RFI

RFI #: 75
 Date: 3/13/2012
 Job: EB-02 Keller Springs Lofts
 Phone: 877-777-5115

Subject: Forming grade beams per SK#1

Subject: Dowels at Pier Caps

1 TYPICAL DRILLED PIER DETAIL
S3.01 NO SCALE

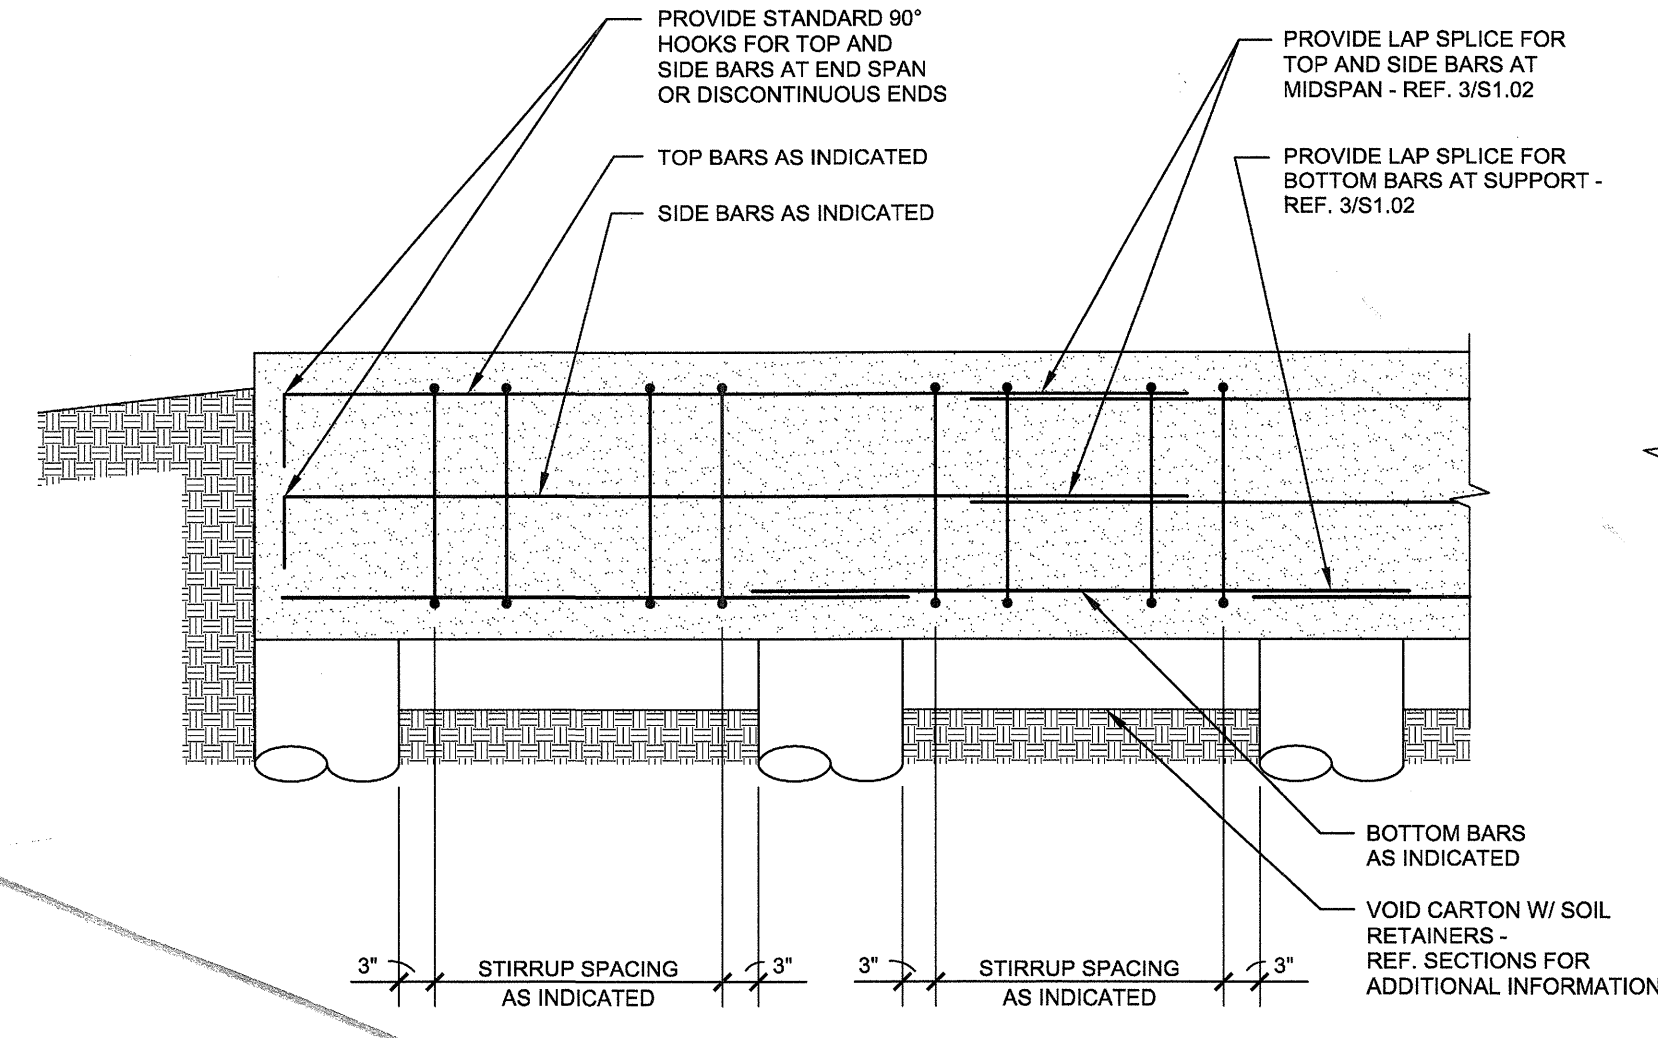
Request: Date Required: 3/22/2012
 In our meeting on 3/16/12 at your office we discussed the already poured piers on slab pour #1 as having 4-#6's of dowels as shown on 1/SG3.01 vs the proper detail as shown on 3/SG3.02, which requires 6 #7 dowels. You were going to check to see if we can reduce the required number of #7 dowels to go along with the in place #6 dowels.

Per our discussion, the 17'-0" minimum depth requirement indicated in 1/SG3.01 does not need to be met provided that the piers penetrate a minimum of 5'-0" into the bearing strata as indicated on the structural drawings. If you have questions or require additional information regarding this matter, please do not hesitate to contact us.

Please provide 4 - 7 "L" dowels in addition to the 4-#6 dowels currently in place.
 R. Trent Perkins, PE
 Parkin-Perkins-Olsen Consulting Engineering, Inc.
 March 22, 2012
